Council Reference: DA09/0701.03 LN35979
Your Reference:

Development Application DA09/0701.03 - amendment to Development Consent DA09/0701 for a 251 lot residential subdivision (Department of Planning Application MP09_0166 MOD 3) at Lot 1 DP 169490, Lot 1 DP 175235, Lot 1 DP 304649, Lot 1 DP 781687, Lot 1 DP 781697, and Lots 40 & 43 DP 254416: No. 37 Fraser Drive TERRANORA; Lot 2 DP 778727: Parkes Lane TERRANORA

I refer to your email of 6 August 2019 in which you notify Tweed Shire Council of the Proponents' Response to Submissions regarding the subject Modification.

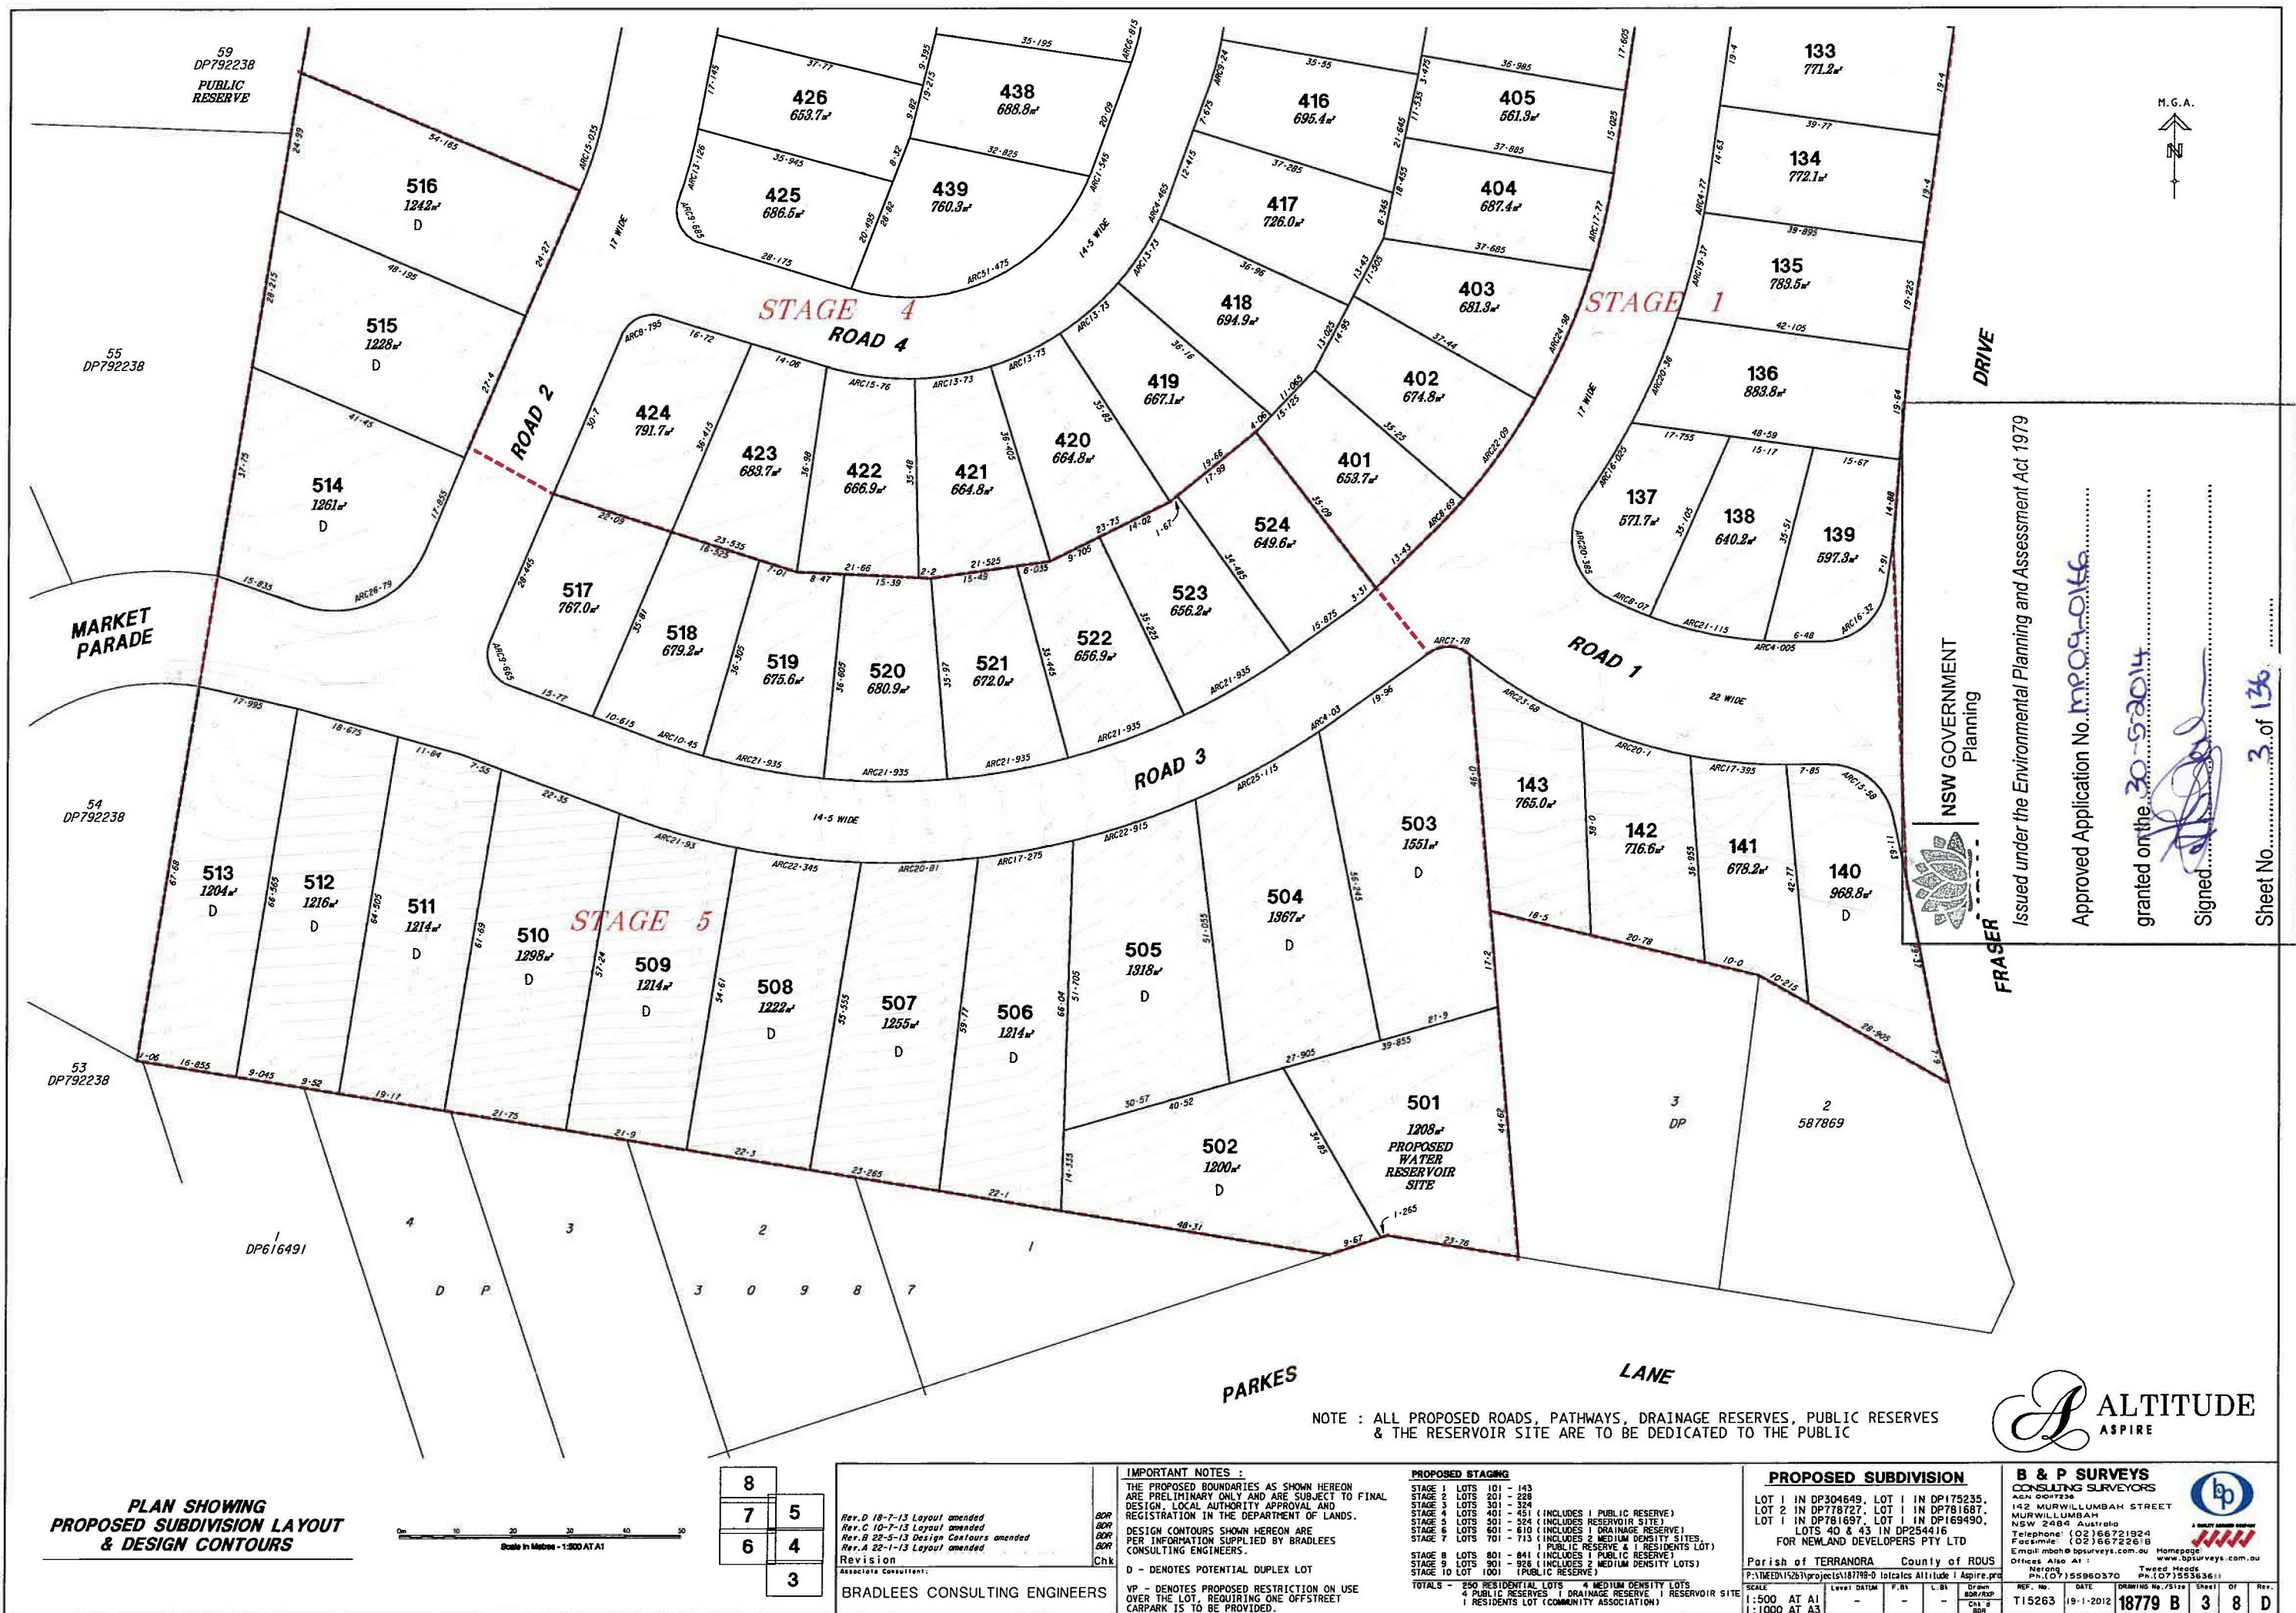
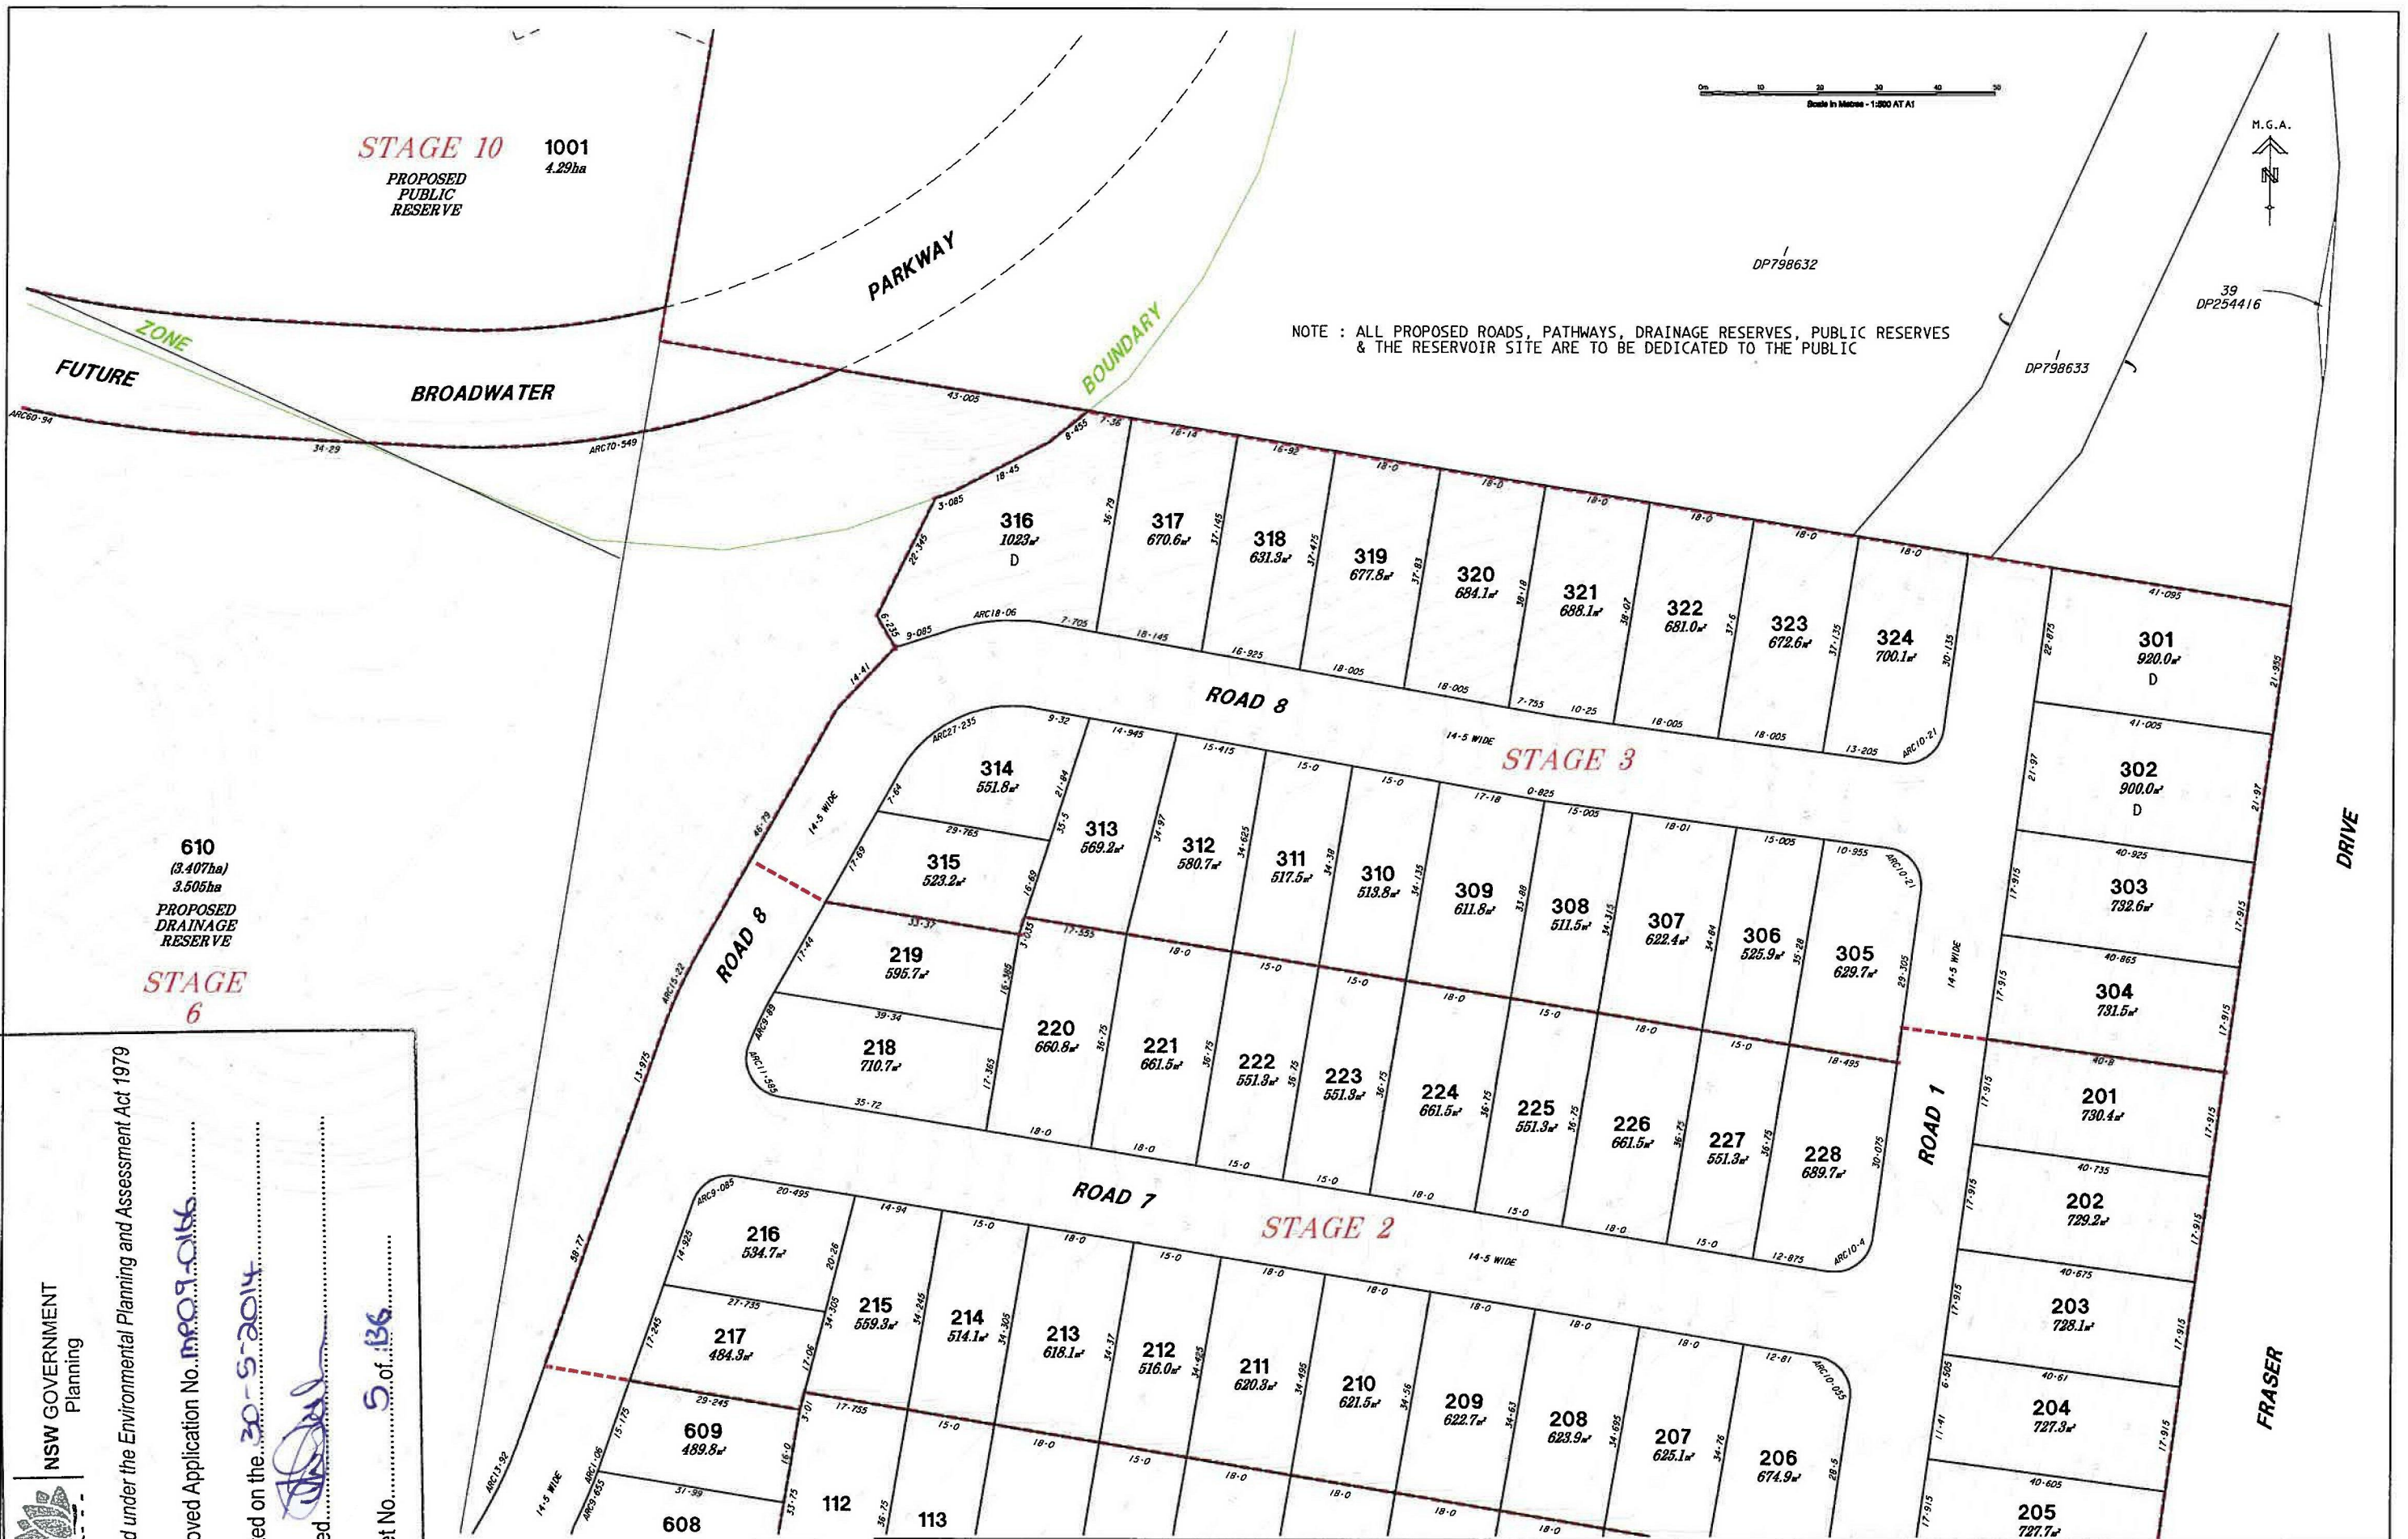
- SK 3608 is the longitudinal section for Road 9, and has been satisfactorily amended to accord with DA Condition B10, however no other associated plans have been changed to reflect Road 9 becoming a cul-de-sac – eg: the separate list of 'Local Office Architecture' plans; engineering plans for 'Road Hierarchy', stormwater, sewer and water provisioning.
- While the Surveyor's subdivision layout plans have been amended to reflect this road change, the supporting engineering drawings were not correspondingly changed. This occurred as part of MOD #2 so will not be further pursued (now).
- It is not considered necessary to amend all other engineering drawings that show Road 9 as a 'through road', provided Condition B10 is retained.

Condition B10 (changing Road 9 to a cul-de-sac): Council withdraws its prior recommendation and support for deletion of this condition, as per comments under Condition A3. This Condition needs to be retained to explain the differences between the Surveyor's subdivision layout plans and the inconsistently amended engineering drawings, relative to Road 9.

Please retain this condition.
